Our Case Number: ACP-323836-25

Re: The proposed development consists of the construction of a new Footbridge and resurfacing of existing lane with walkway link to the existing park in the form of new footpaths and all ancillary site works as required to complete the works.
Newport Ball Alley and Park, Newport, Co Tipperary.

Objection to the Planning Notice for the Newport Ball Alley Footbridge, REF ACP323836

Proposed Site Plan

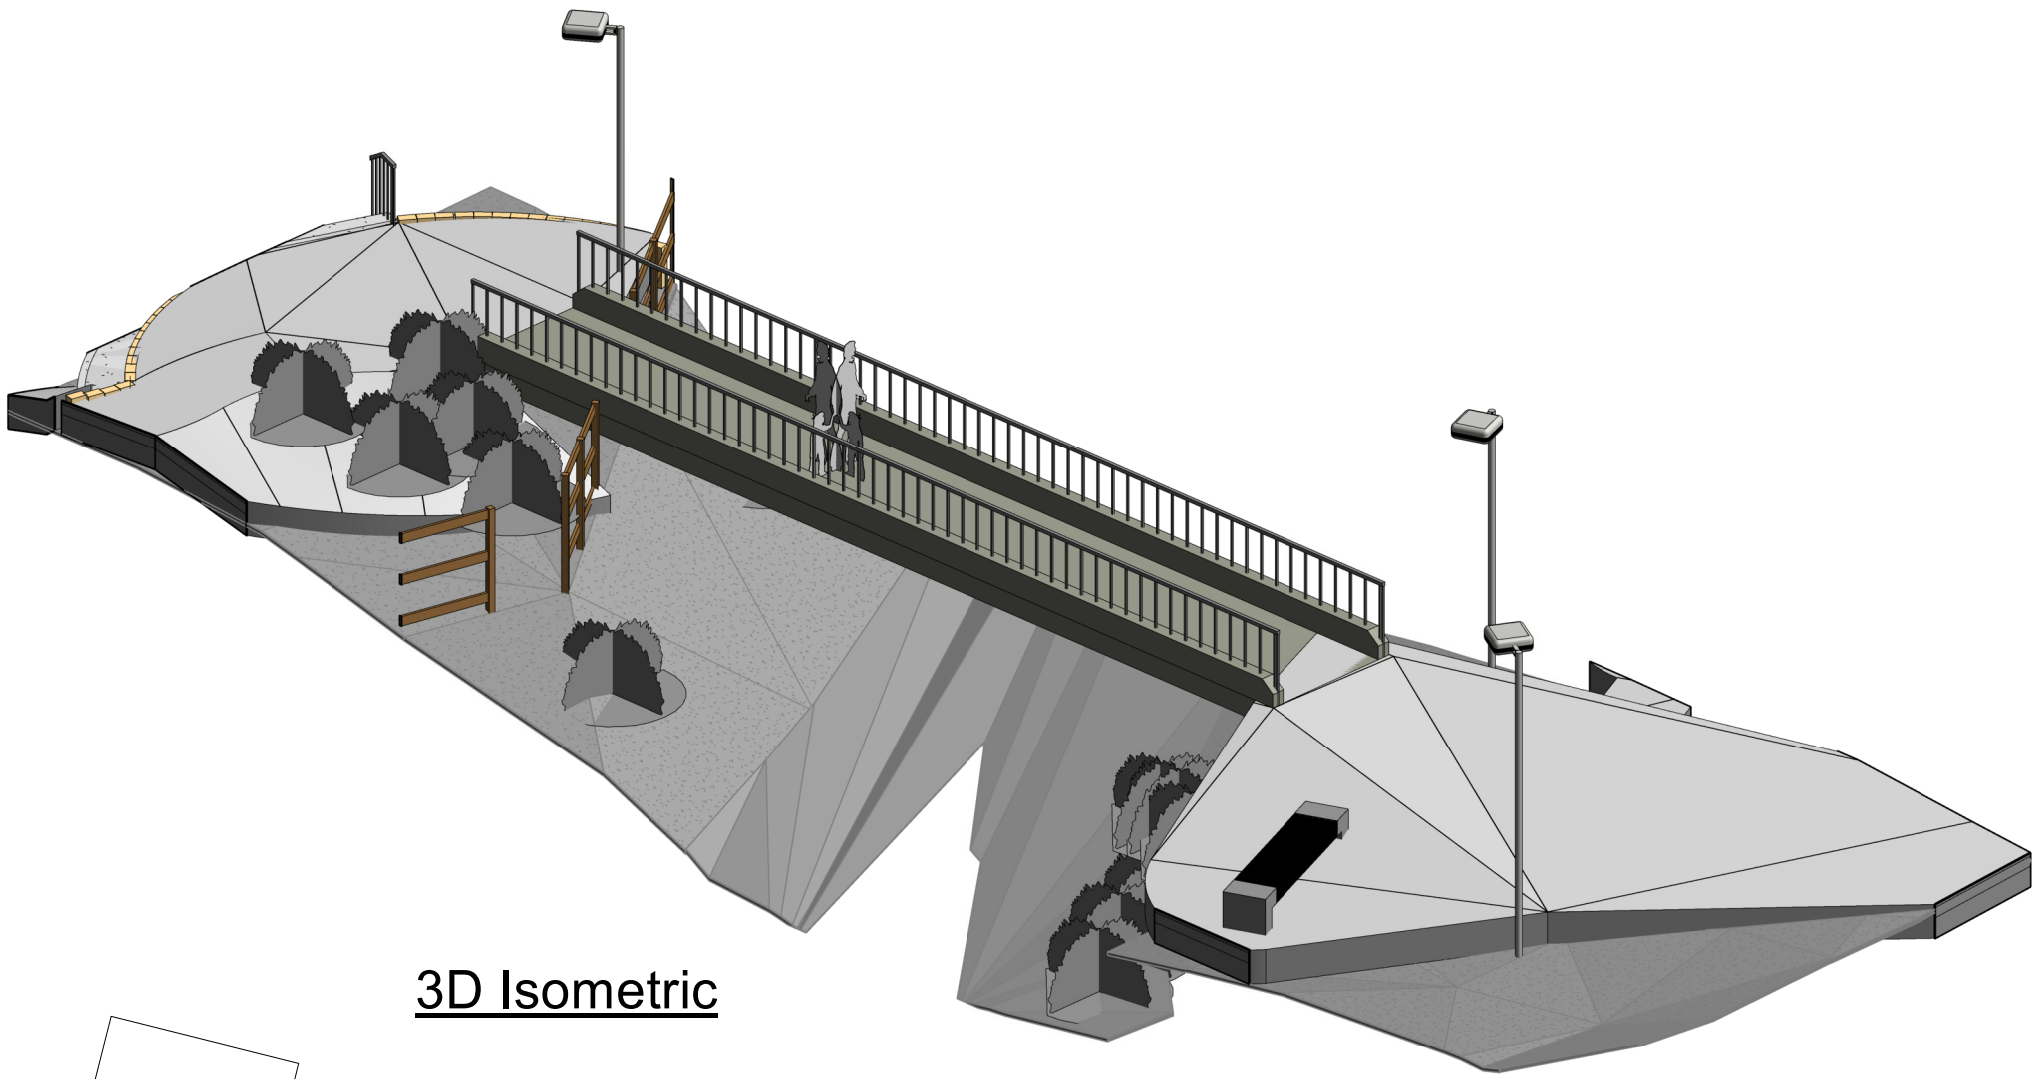
Our concern is, the proposed footbridge would create a link from the ball alley directly to the rear of our property, to a very secluded area of the town. This secluded area is the proposed picnic bench area, to the rear of our property. We fear this would become an extension of the current loitering area and therefore the antisocial behaviour it enables.

A further concern involves the existing access route to the ball alley, as this access appears to belong to a private property. Because of this, we fear this access route may be closed off once the new development is in place. The potential closure of the access route causes concerns as we fear all the antisocial behaviour would pass via the side and rear of our property to the ball alley, causing further disruptions.

Proposed Plan

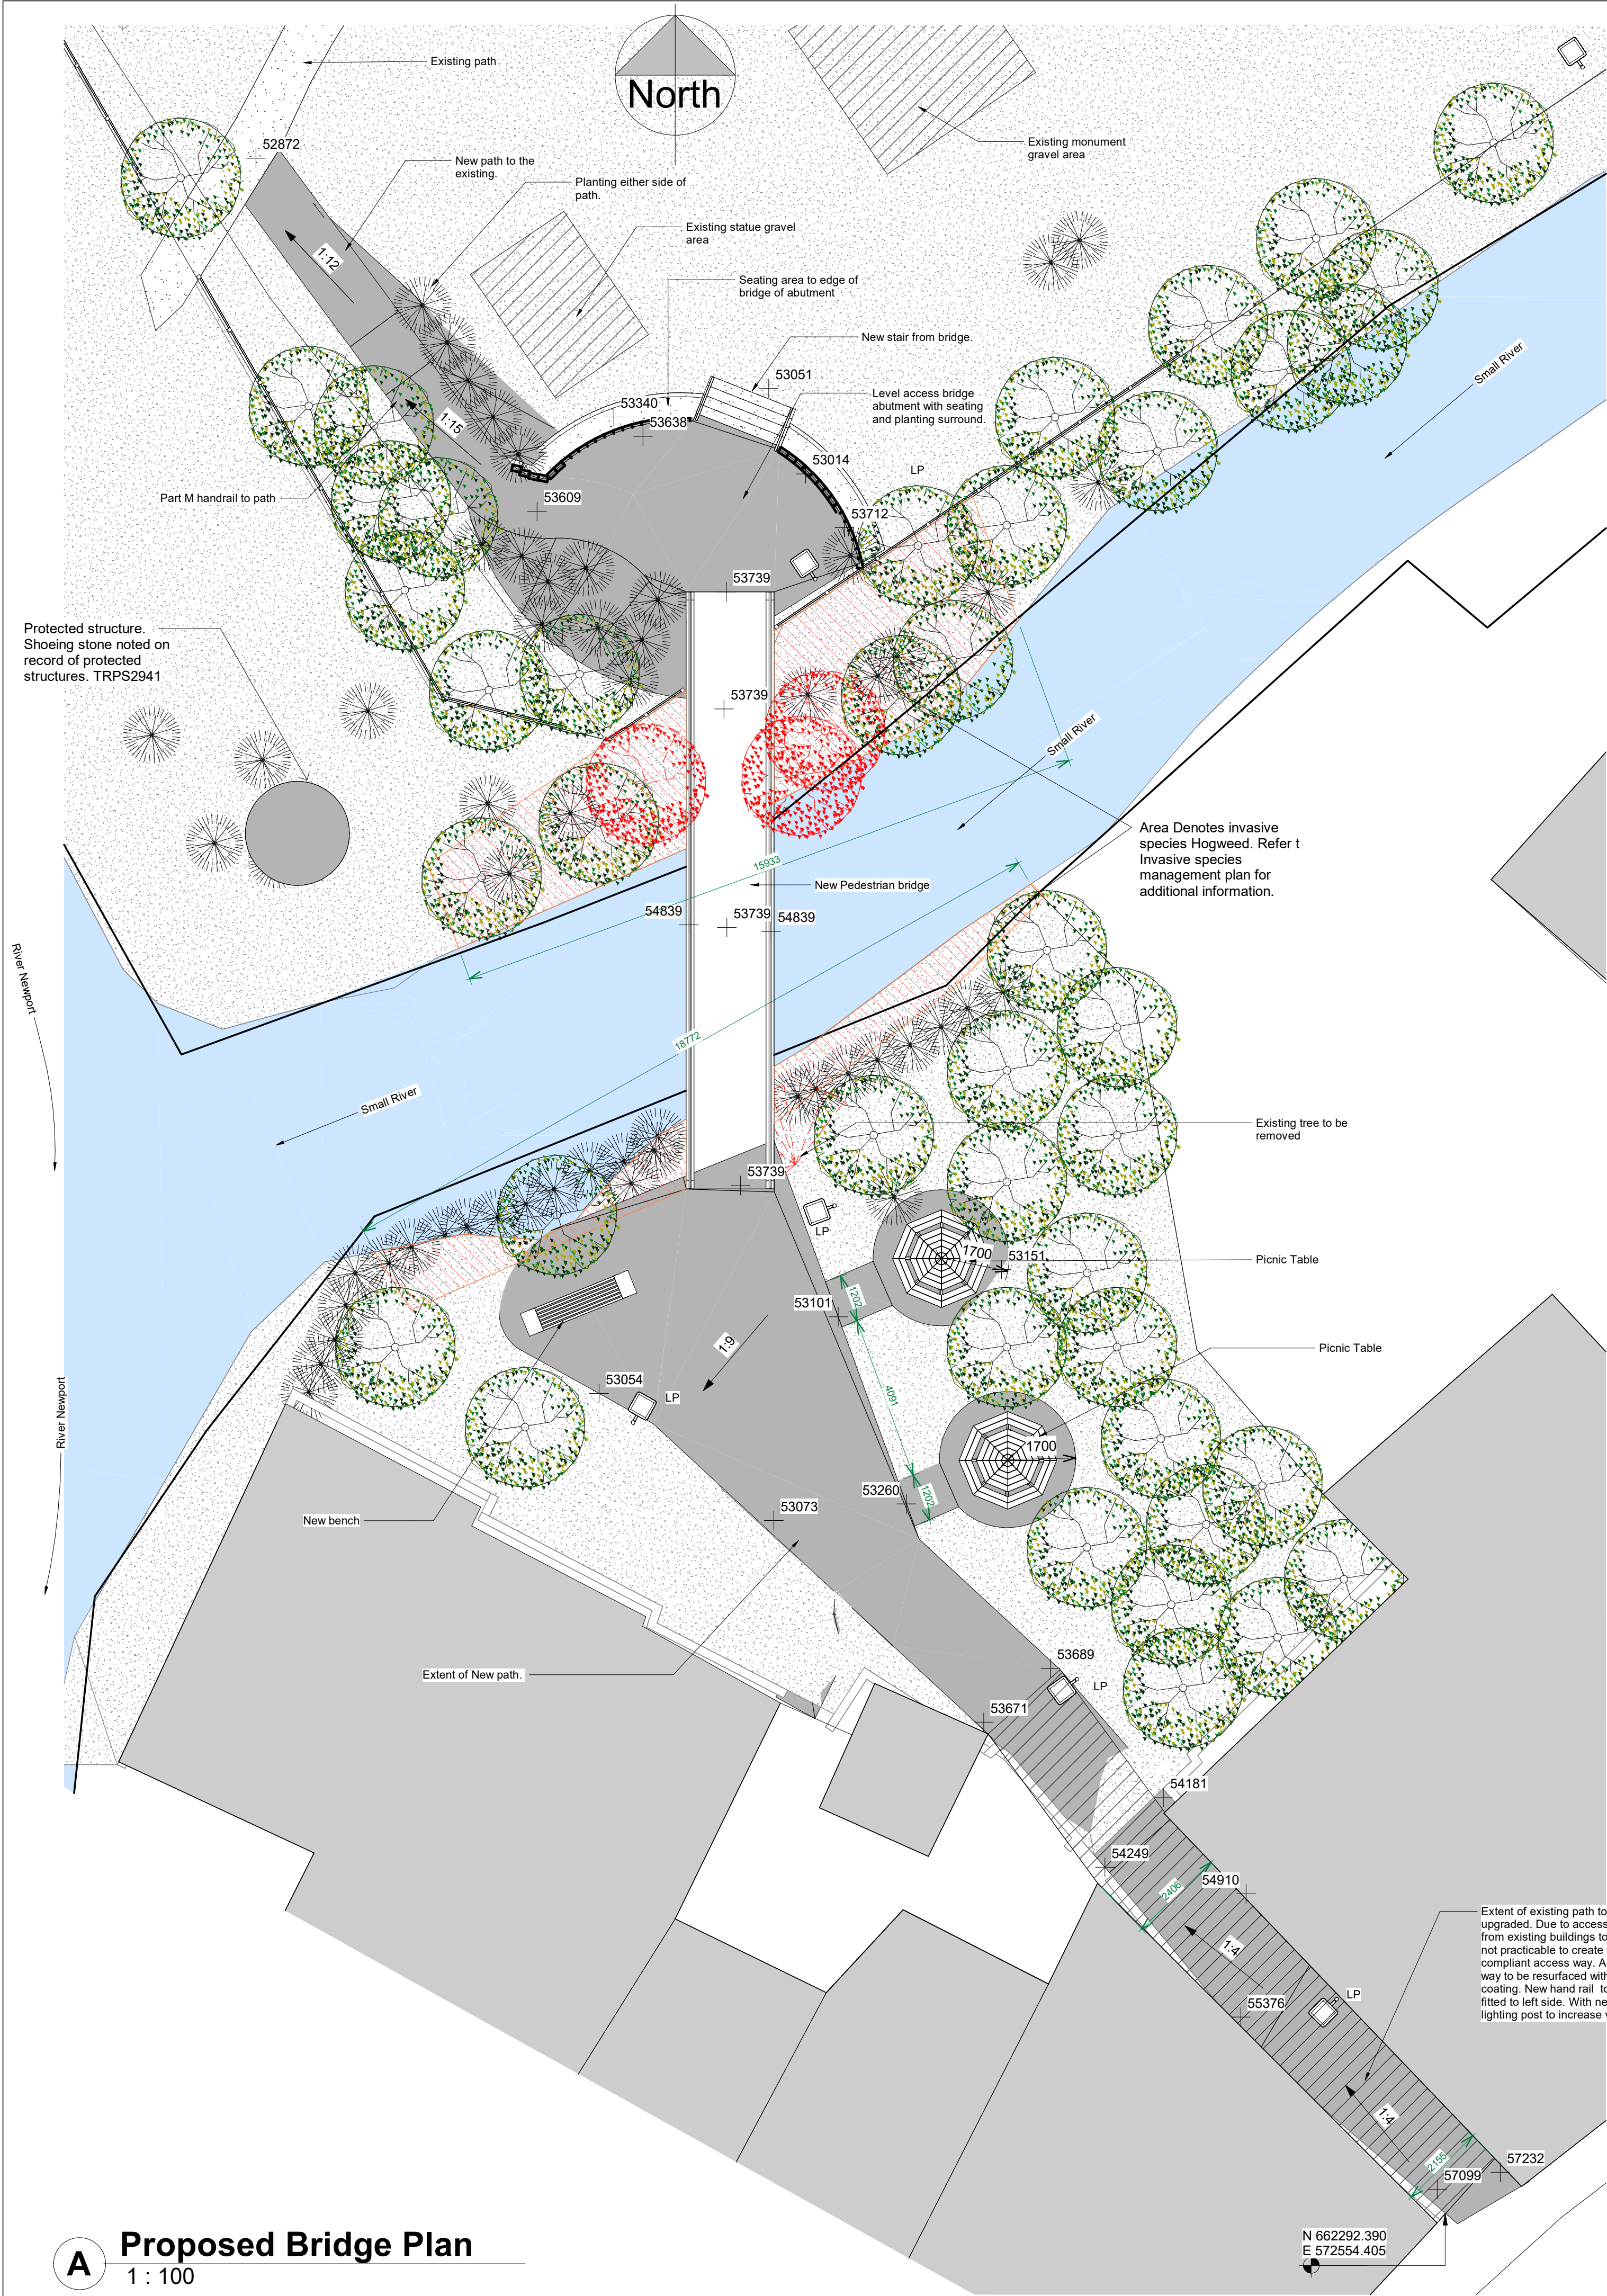
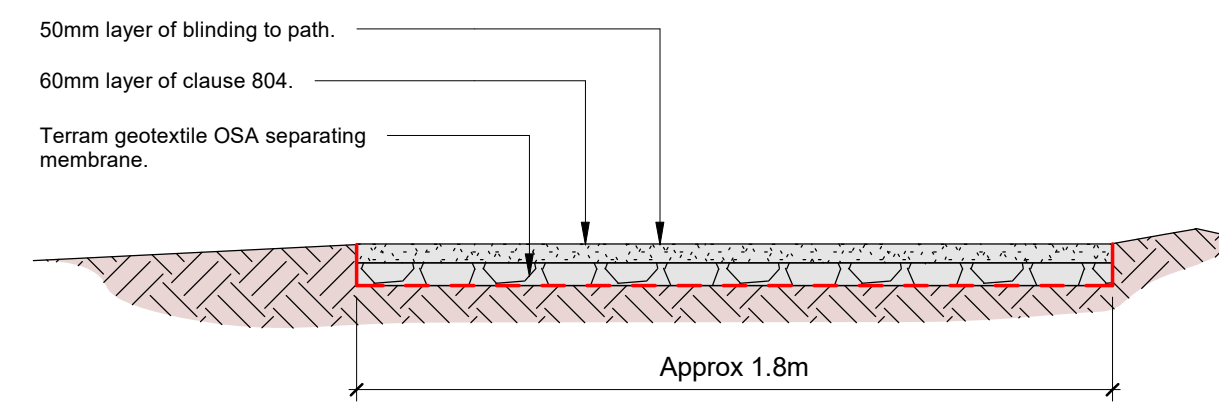
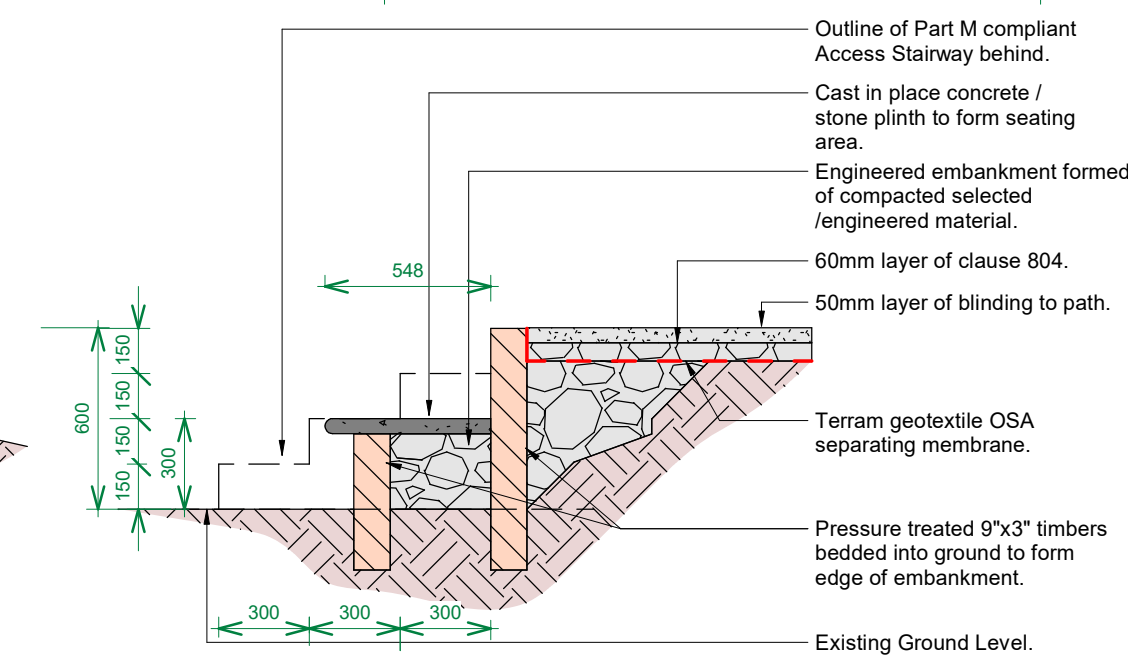
We would also like to note at this laneway is a service corridor for the properties that back onto it. The proposed handrail would narrow the access for those needing to use the laneway to service the rear of our properties. For example, access for maintenance, storage of waste bins, etc.
